BOLTON-BY-BOWLAND, GISBURN FOREST & SAWLEY PARISH COUNCIL

PLANNING APPLICATION NO: *0804/5*
RELATING TO *RODHILL LIDGE, BOLTON-BY-BOWLAND*

SECTION

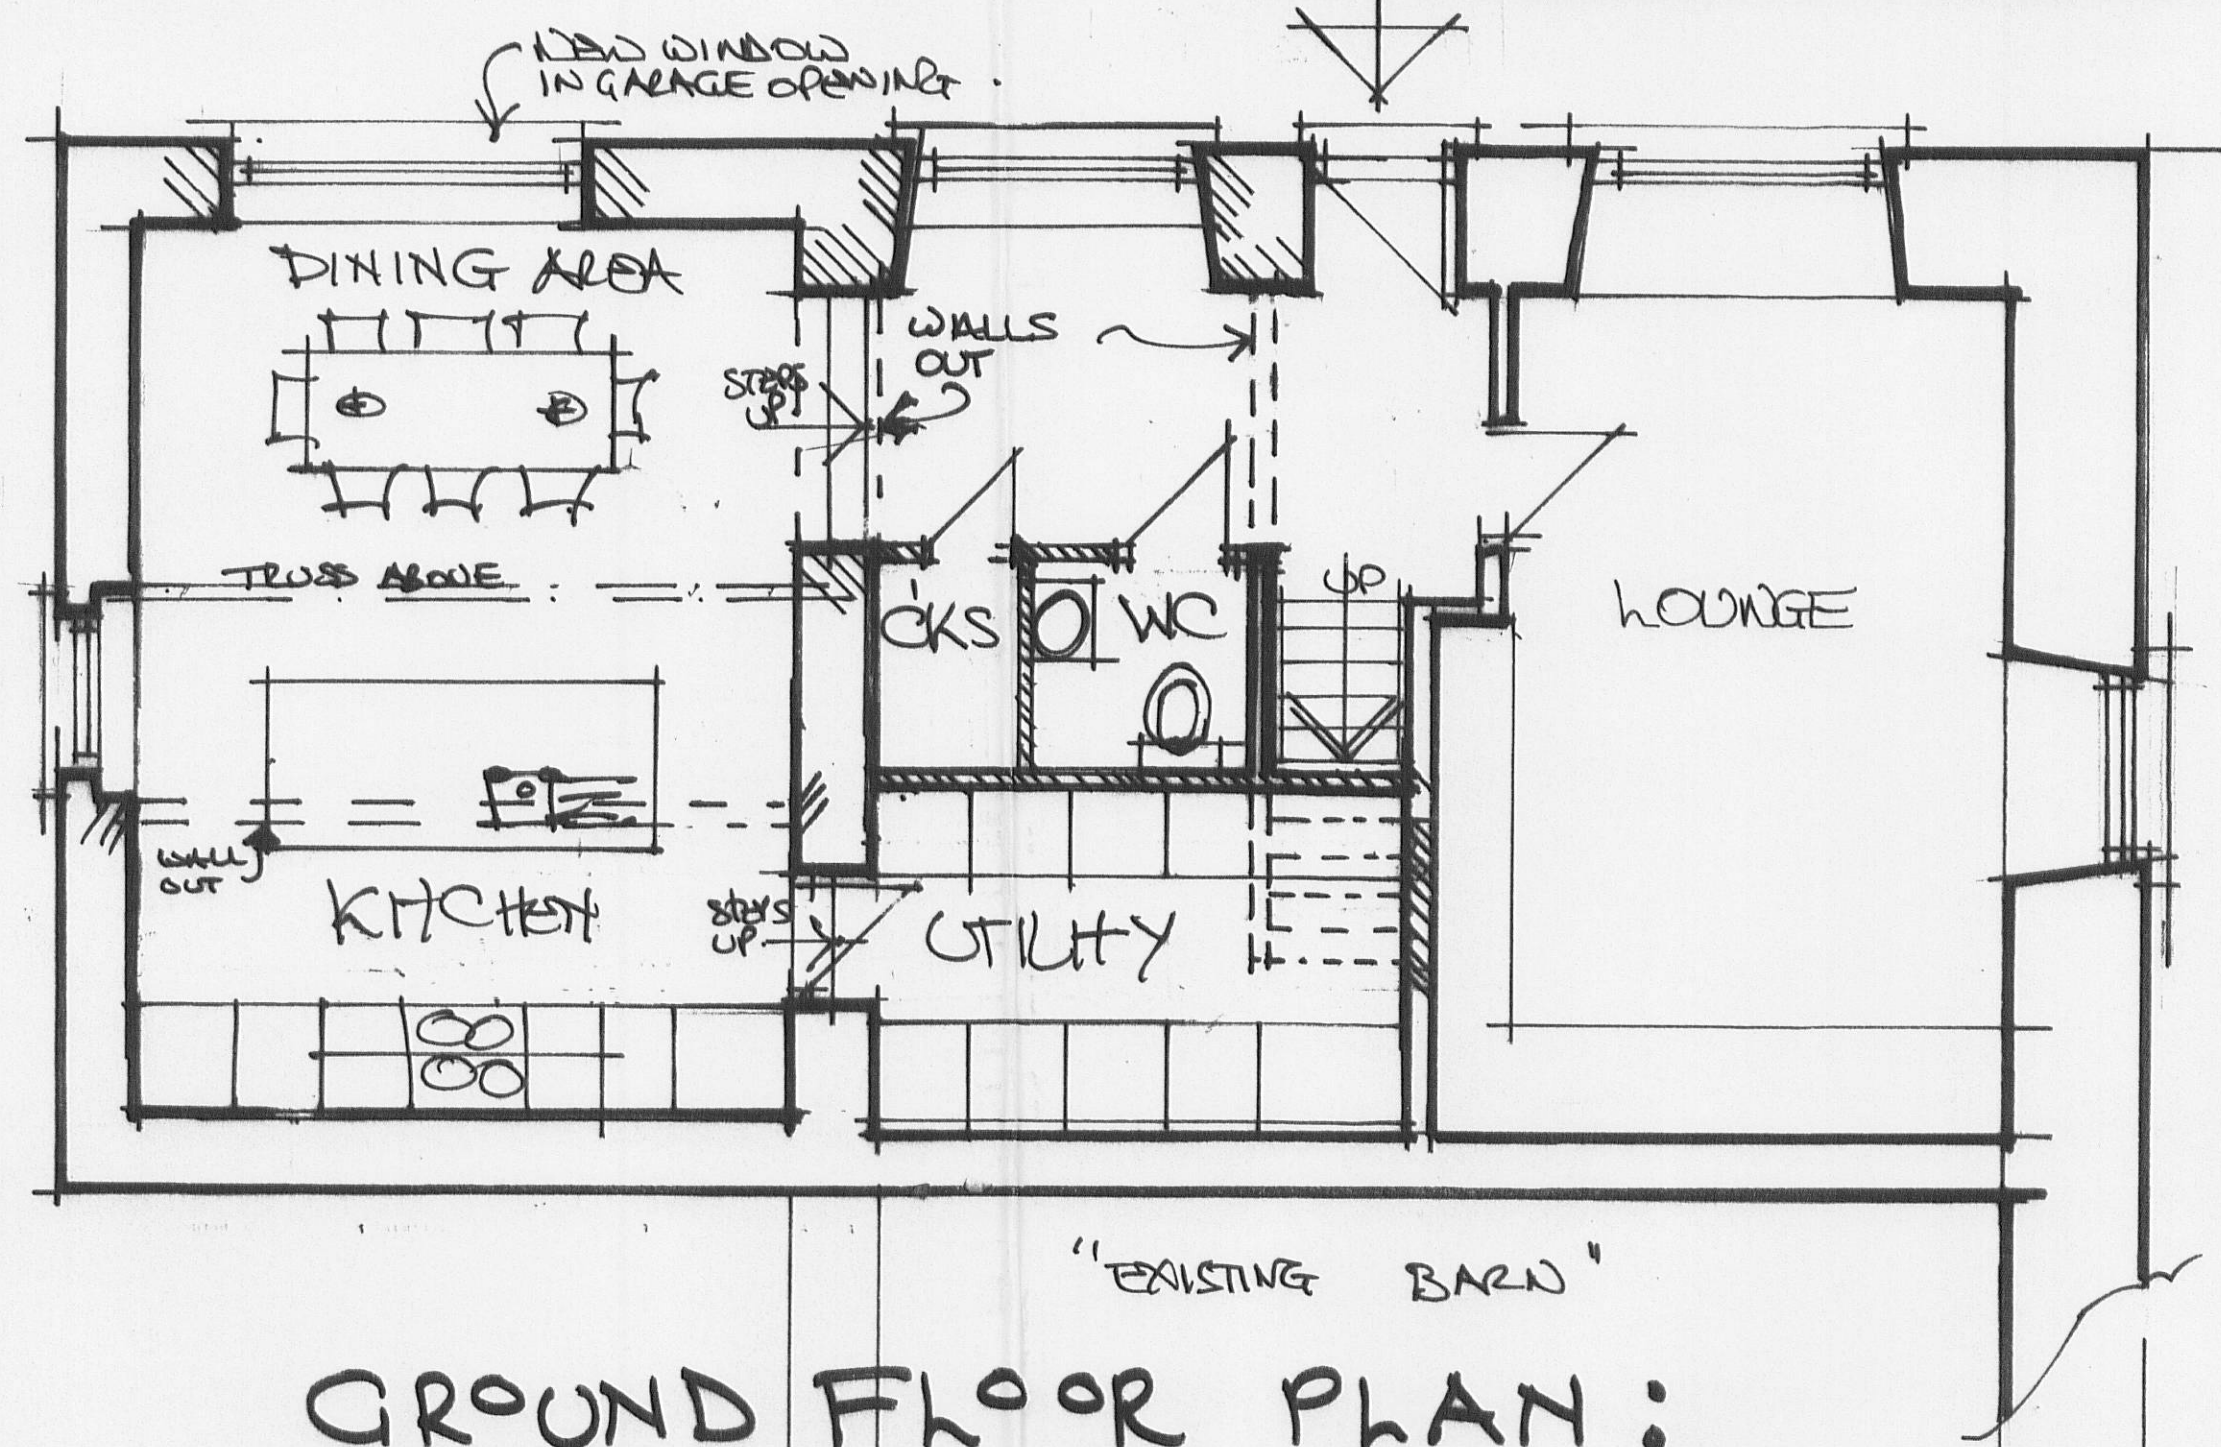
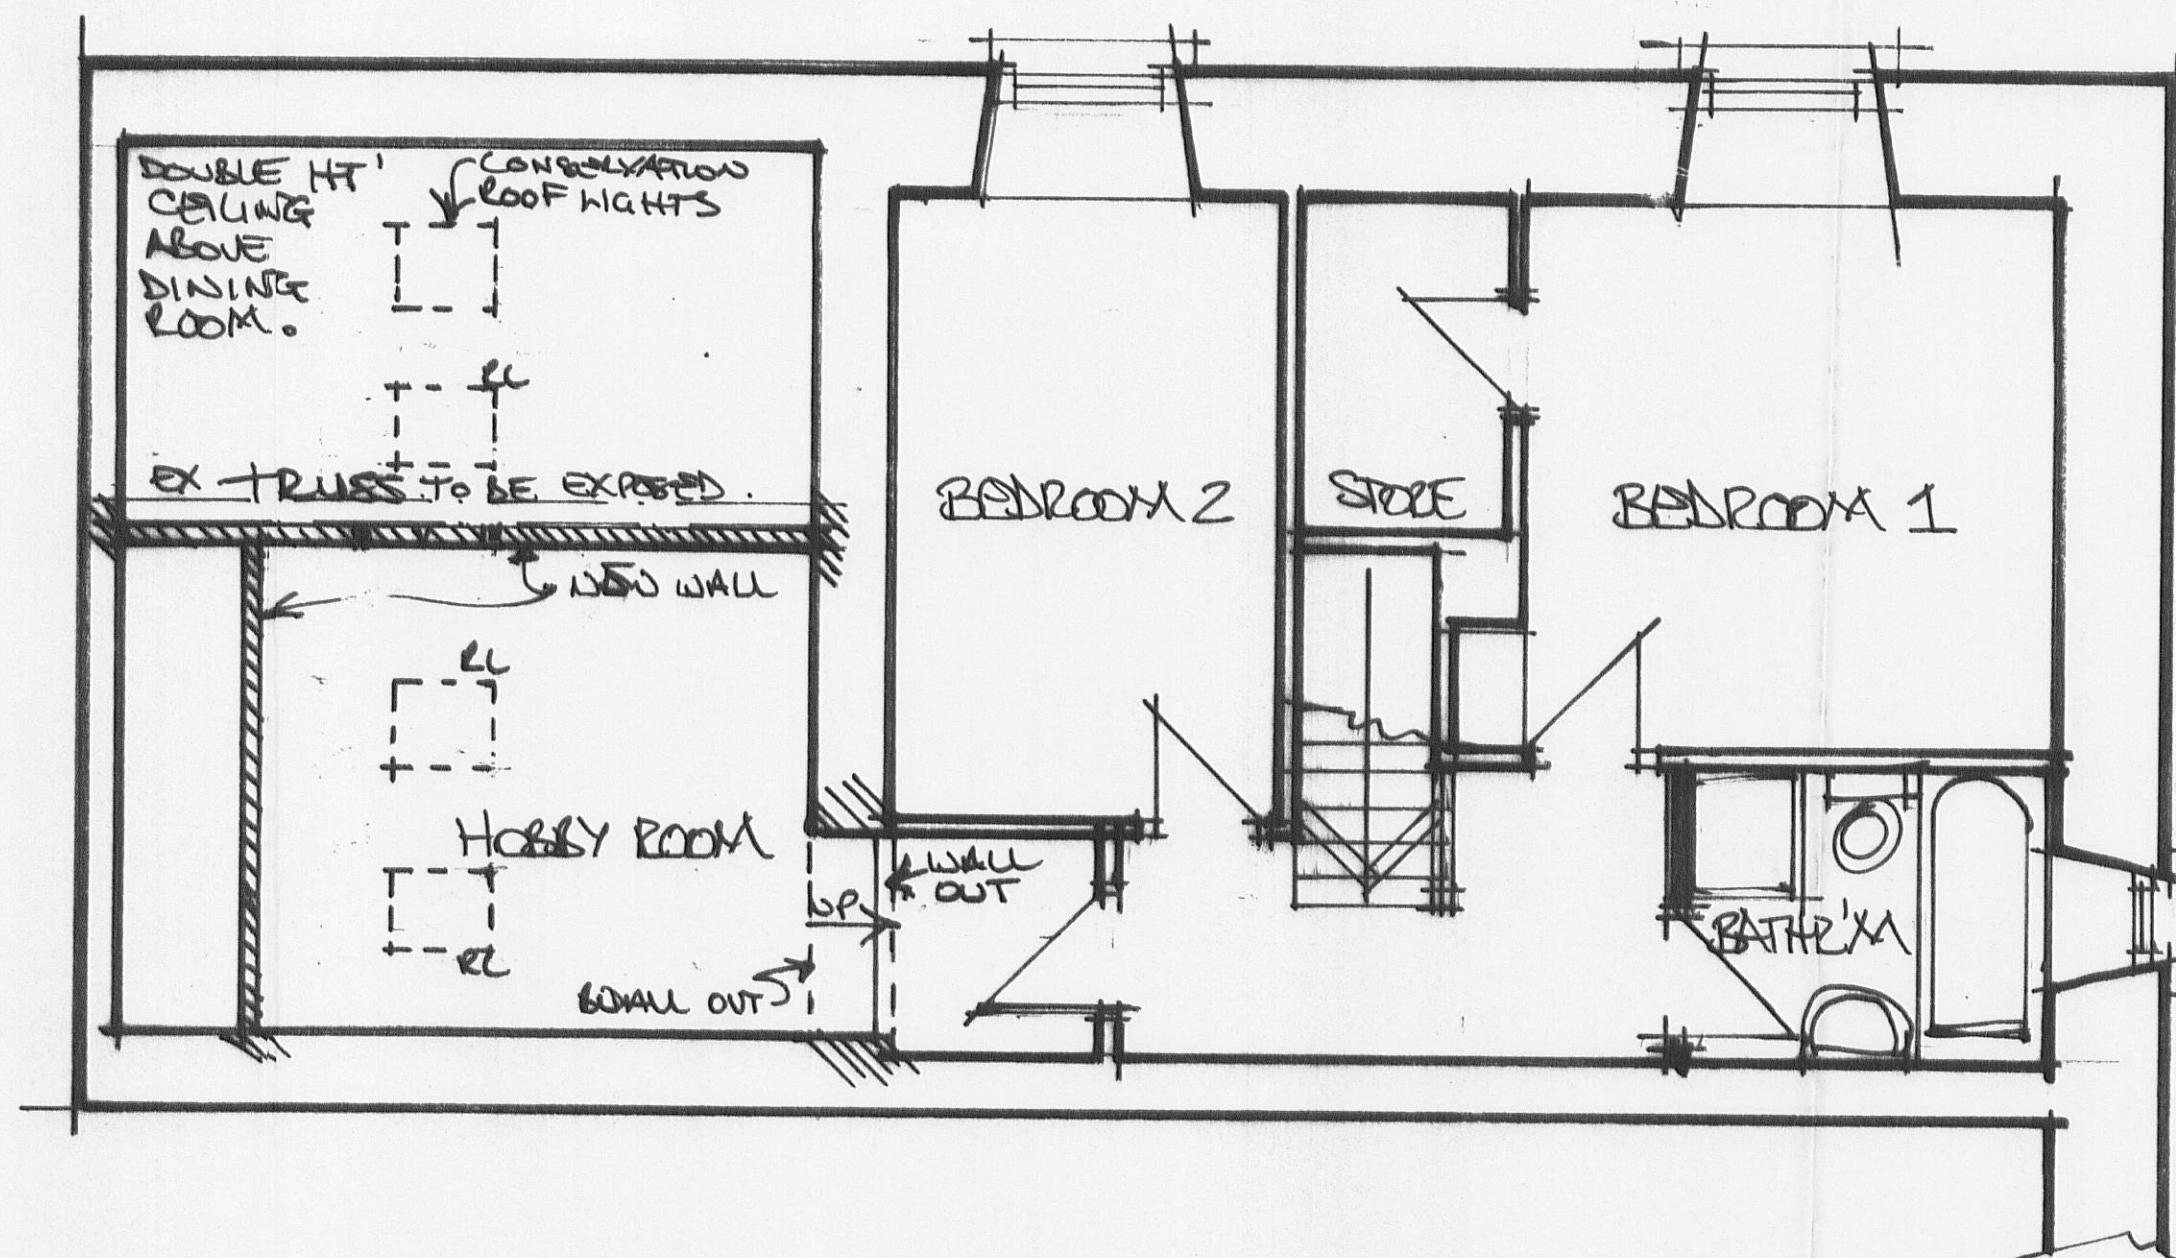
*QUERY THE NEED FOR 4 ROOF
LIGHTS ABOVE LOBBY ROOM*
